Thornleigh Neighbourhood Residents Group

Att: Director- Infrastructure Projects
Department of Planning and Environment
Application number- SSI 13_ 6146
Major Projects Assessment
GPO Box 39 Sydney NSW 2001

Submission on the proposed NorthConnex Tunnel

5 September, 2014

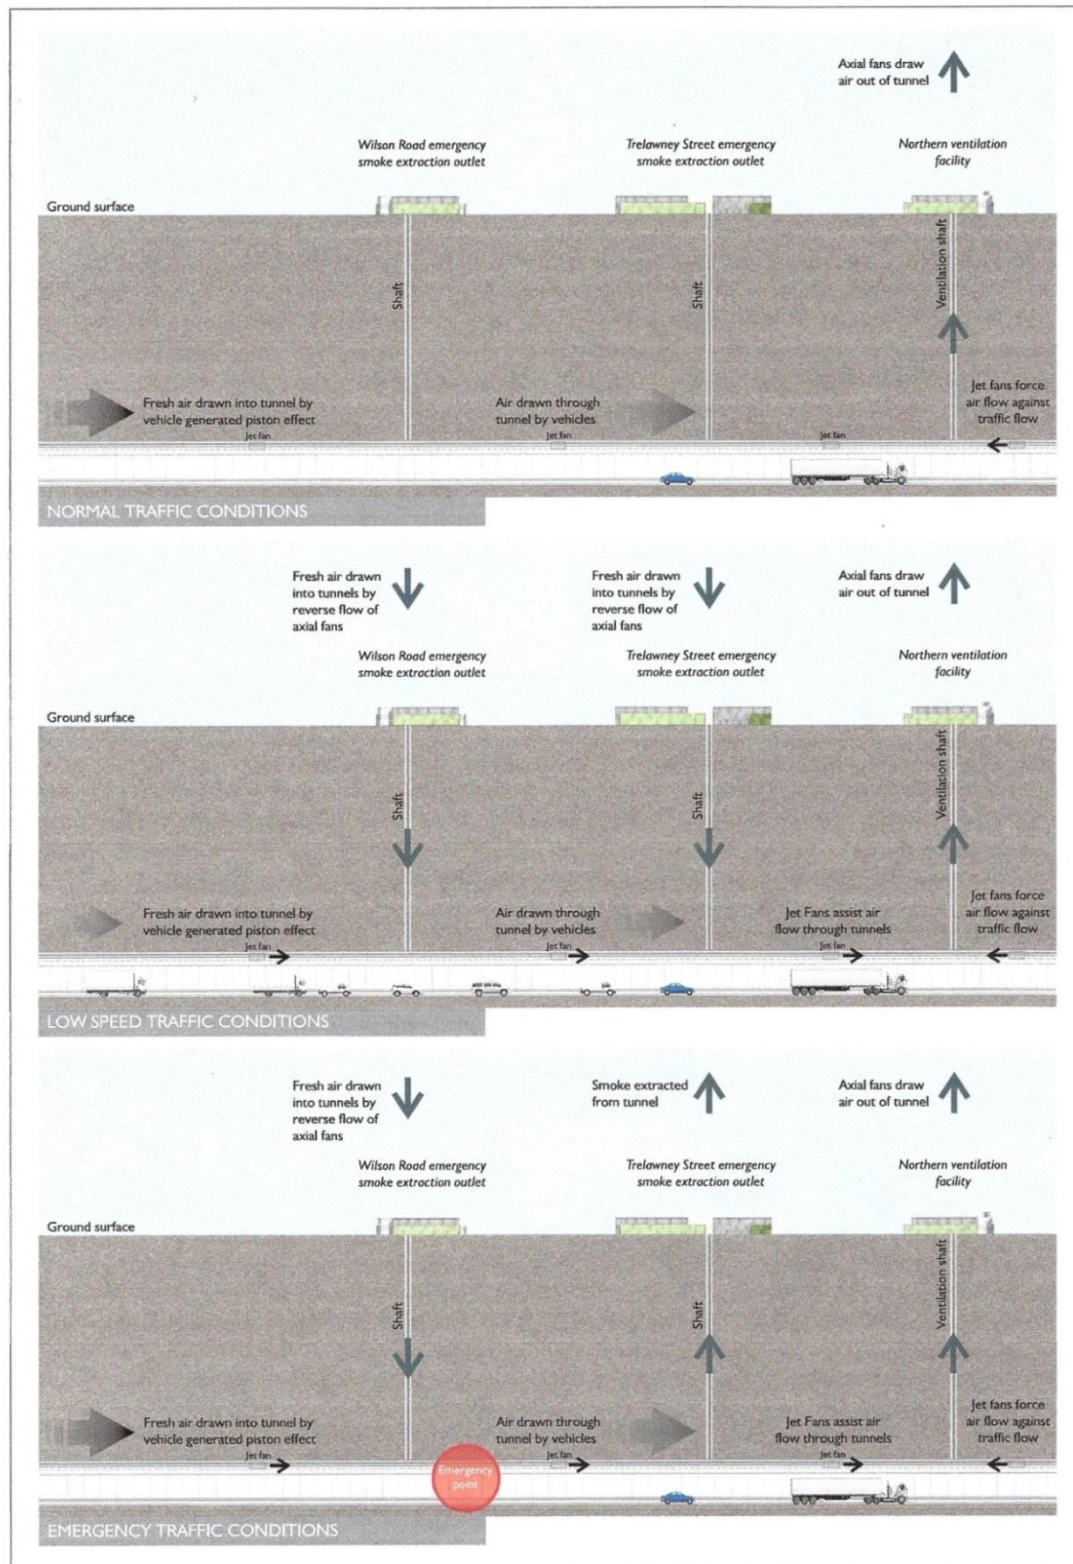
Another issue after building is completed is that the Thornleigh facility shows a very uninspiring building looking more like a sound barrier and with very few trees to soften its bland appearance. This is in contrast to its twin facility at Pennant Hills where the artist impression shows that facility to be set back from Pennant Hills Road and well camouflaged by vegetation. Can the Thornleigh facility be improved to moderate its appearance from Pennant Hills Road?
